November 17, 2025

Re: Warehouse
3050 Todos Santos St NW
30-Day Temporary Certificate of Occupancy
Transportation Development Final Inspection
Architect's Stamp dated 01-02-25 (G10-D029K)
Certification dated 10-28-2025
TRANS-2025-00315

SITE PLAN

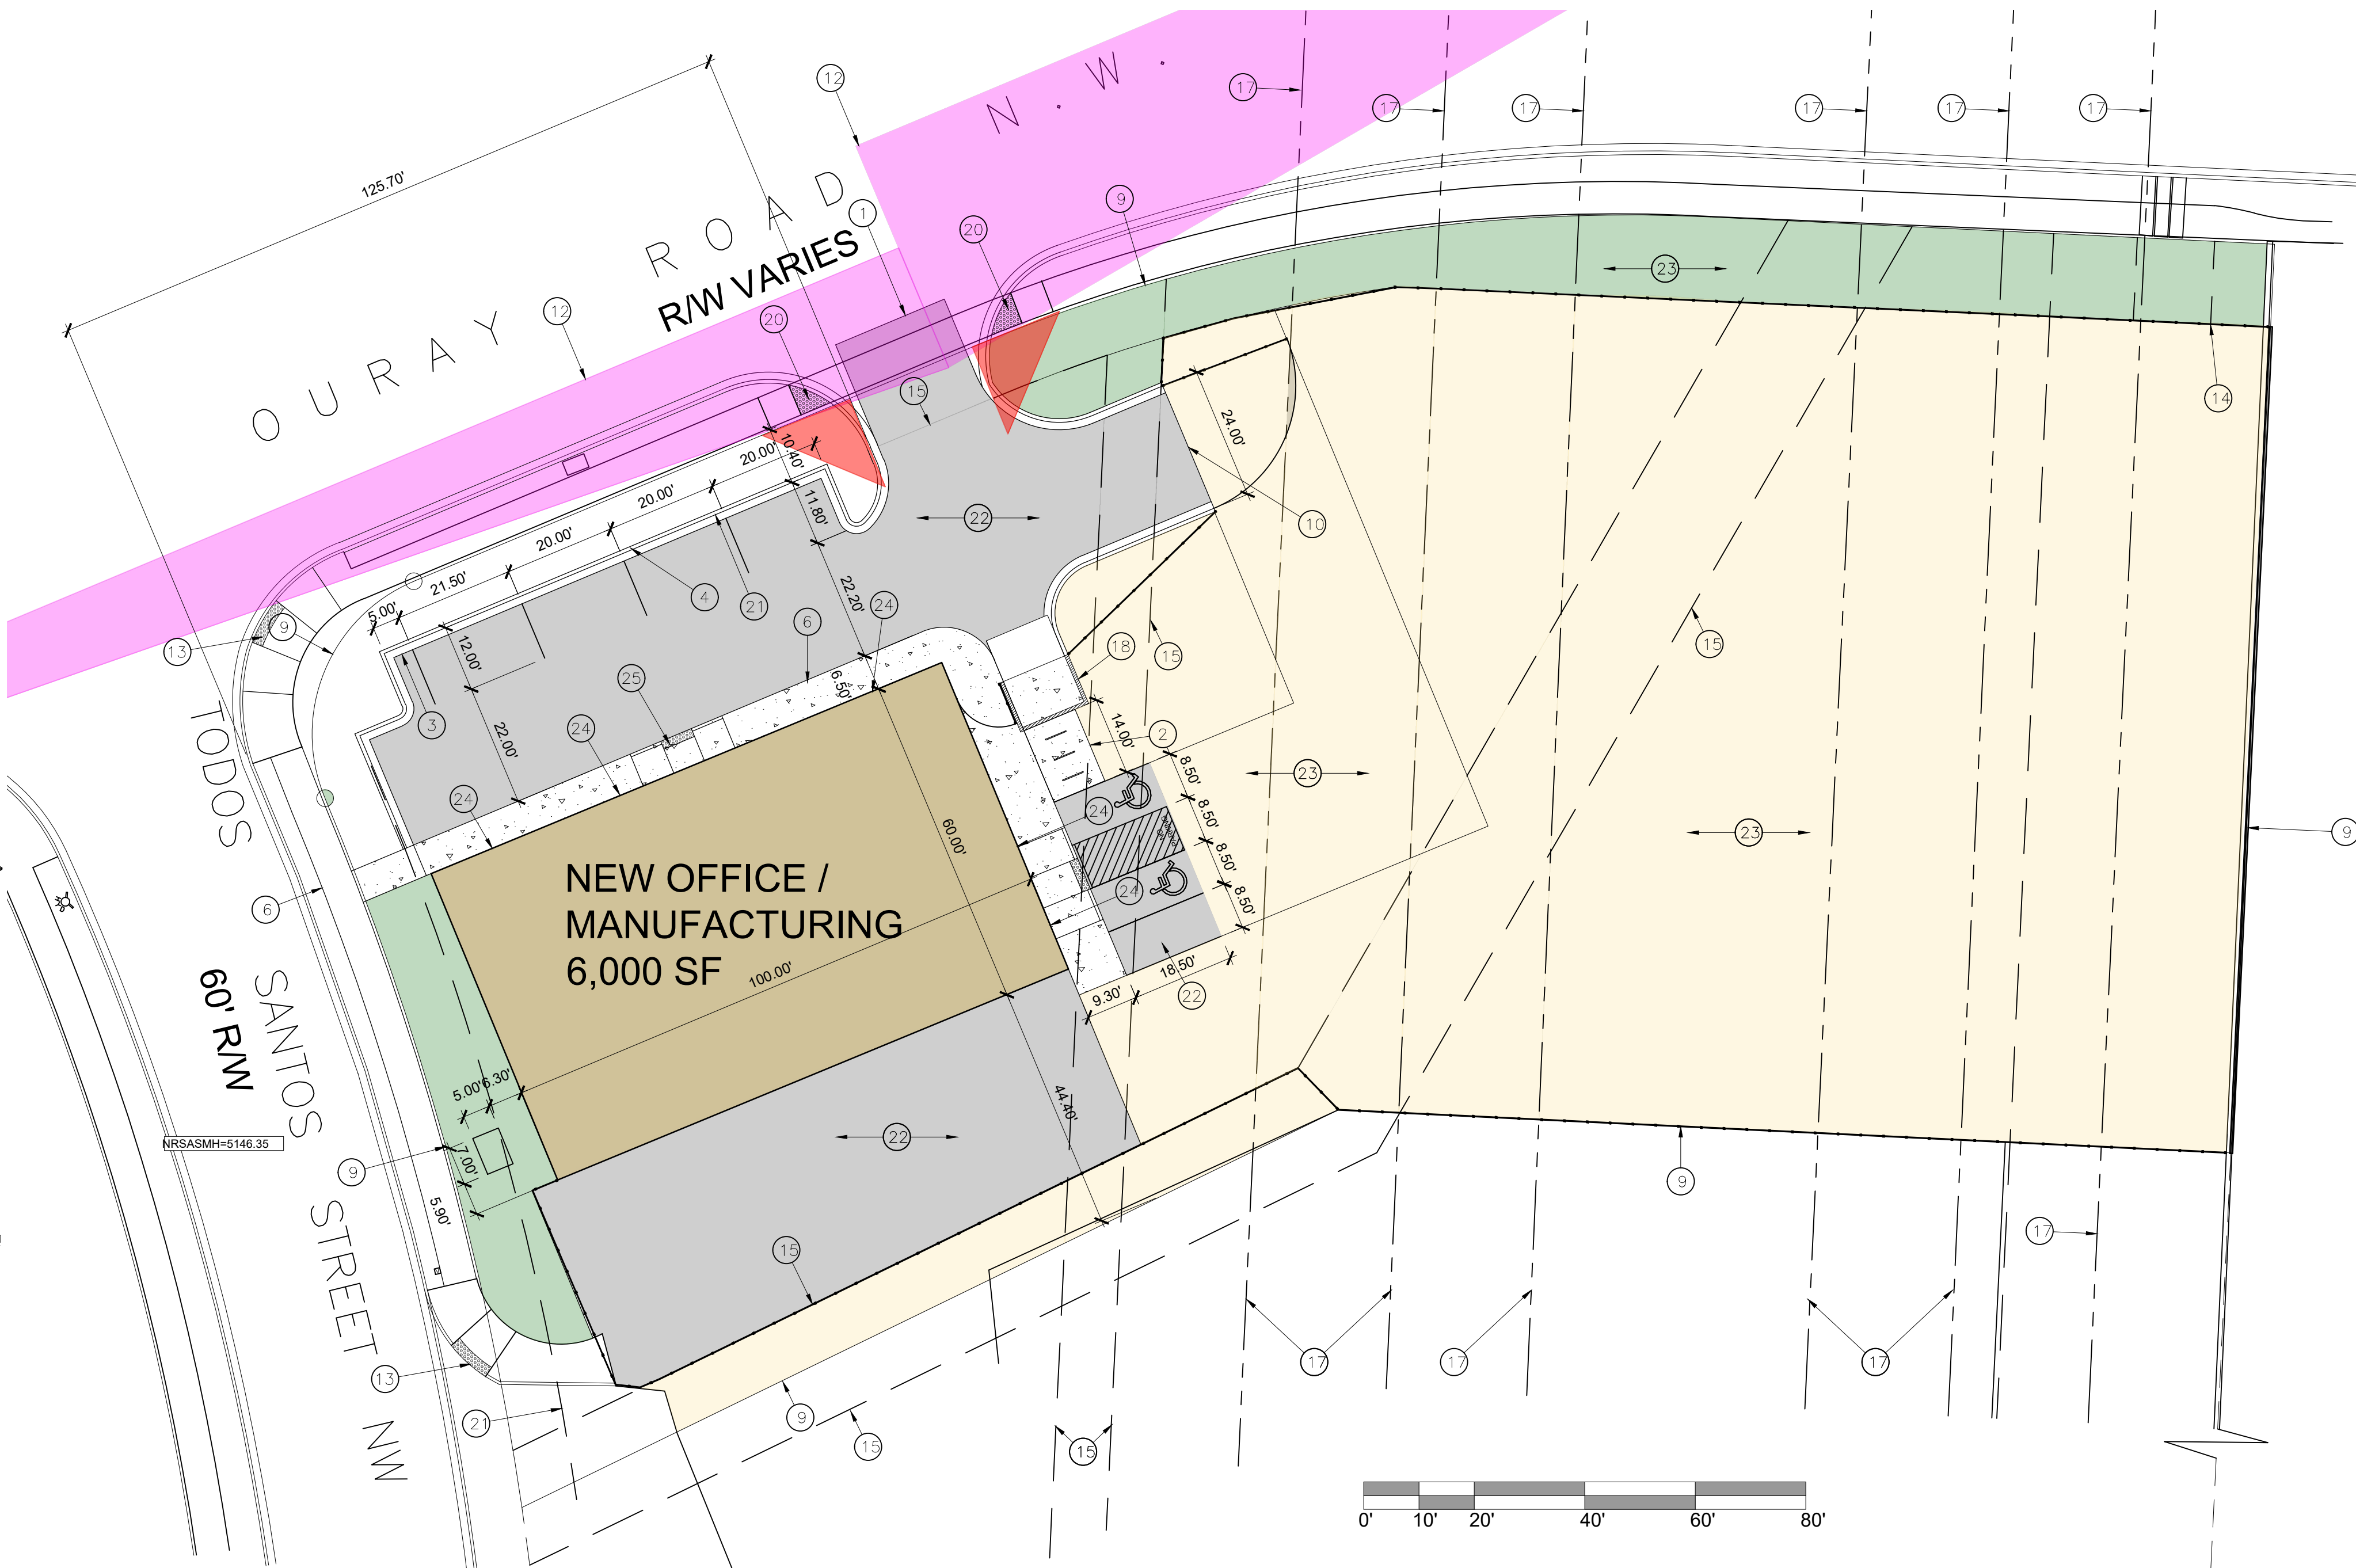
- A Truncated Domes must be installed at the corners of site.
